April 11, 2019

**RE: Amaran Senior Living
9100 Holly Ave NE
Grading and Drainage Plan
Engineer's Stamp Date: 2/15/19
Hydrology File: C20D079**

Based on the submittal received on 4/1/19, this project is cannot be approved for Building Permit until the following are corrected:

CG101
OF

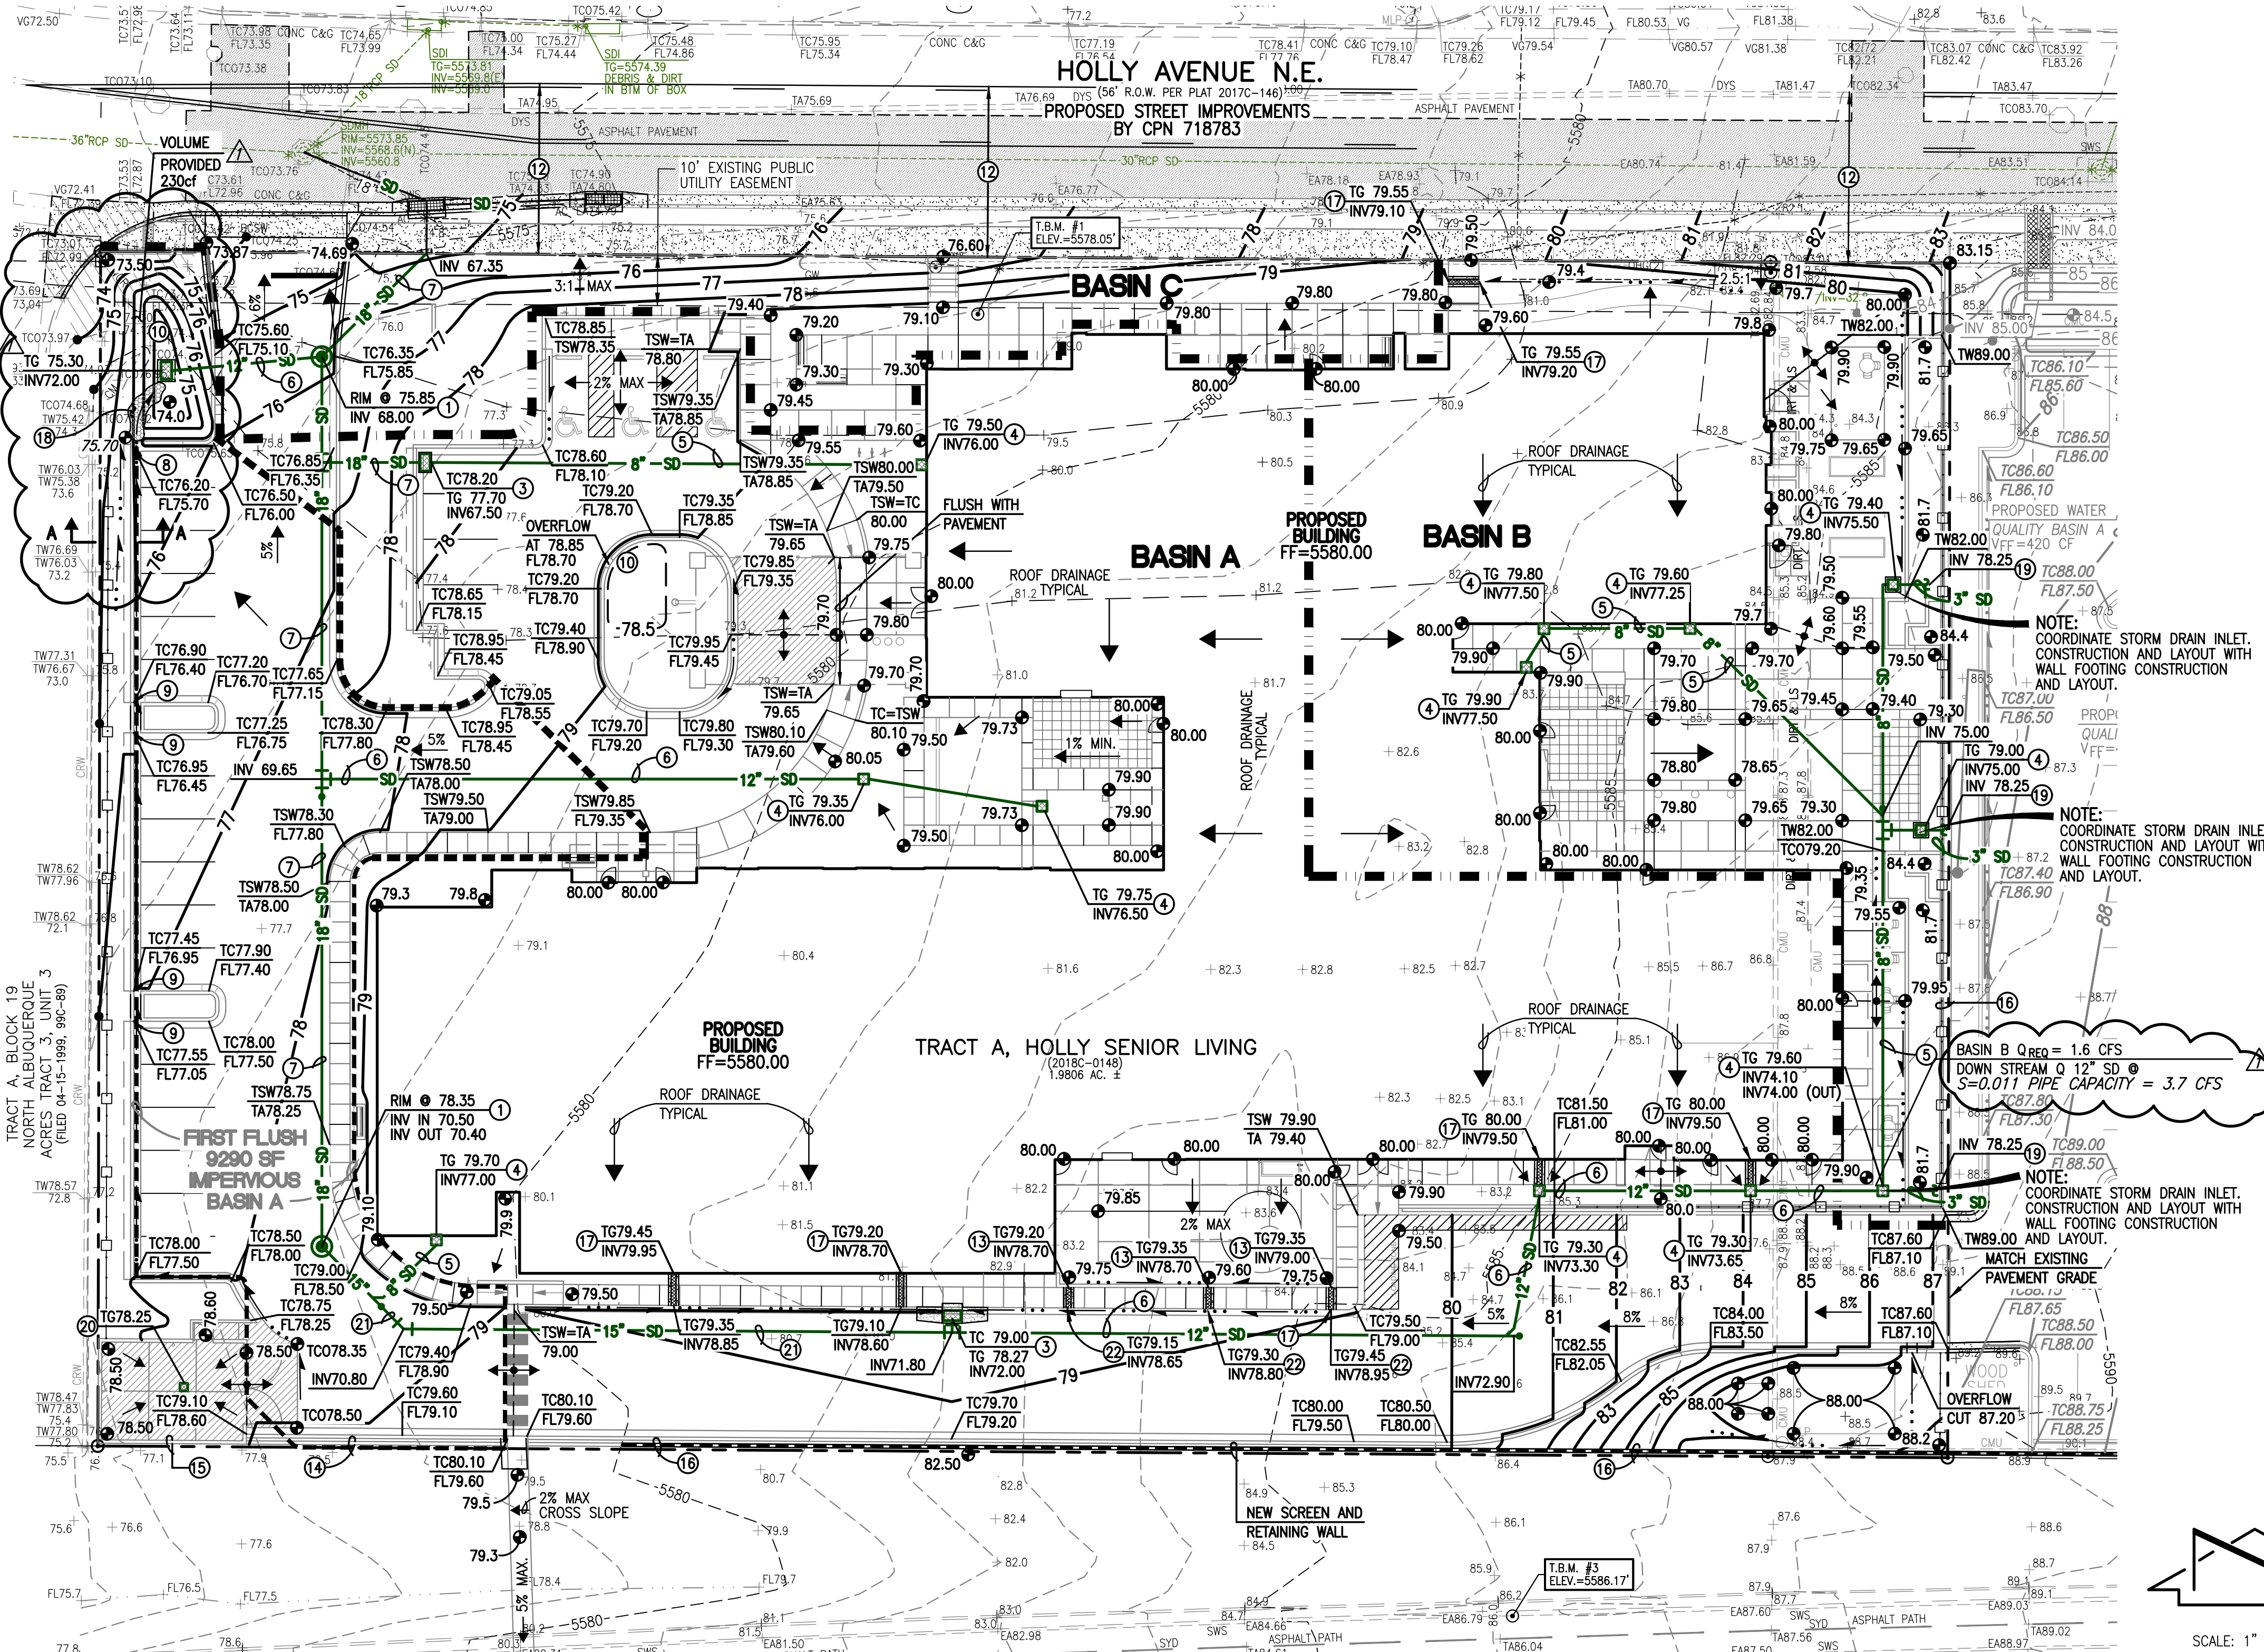
1. Hydraulic Calculations are required per DPM 22.3:
 - a. HGL calculations for the pipe network, determined along the energy grade line, are missing.
 - b. Pond routing and water surface elevations for both the first flush and the 100-year volumes are missing.
 - c. Grate capacity for the pond outlet needs to be checked using 3.72SF clear space (1.86SF w/ 50% clogging). The new grate Standard Detail is attached.
 - d. Provide a section through the pond and property line, showing that the downhill property will not be adversely affected by the placement of the pond.
2. Payment in Lieu (Amount = $2180\text{CF} \times \$8/\text{CF} = \$17,440$, per Sheet C100) of management onsite for the required storm water quality volume must be made
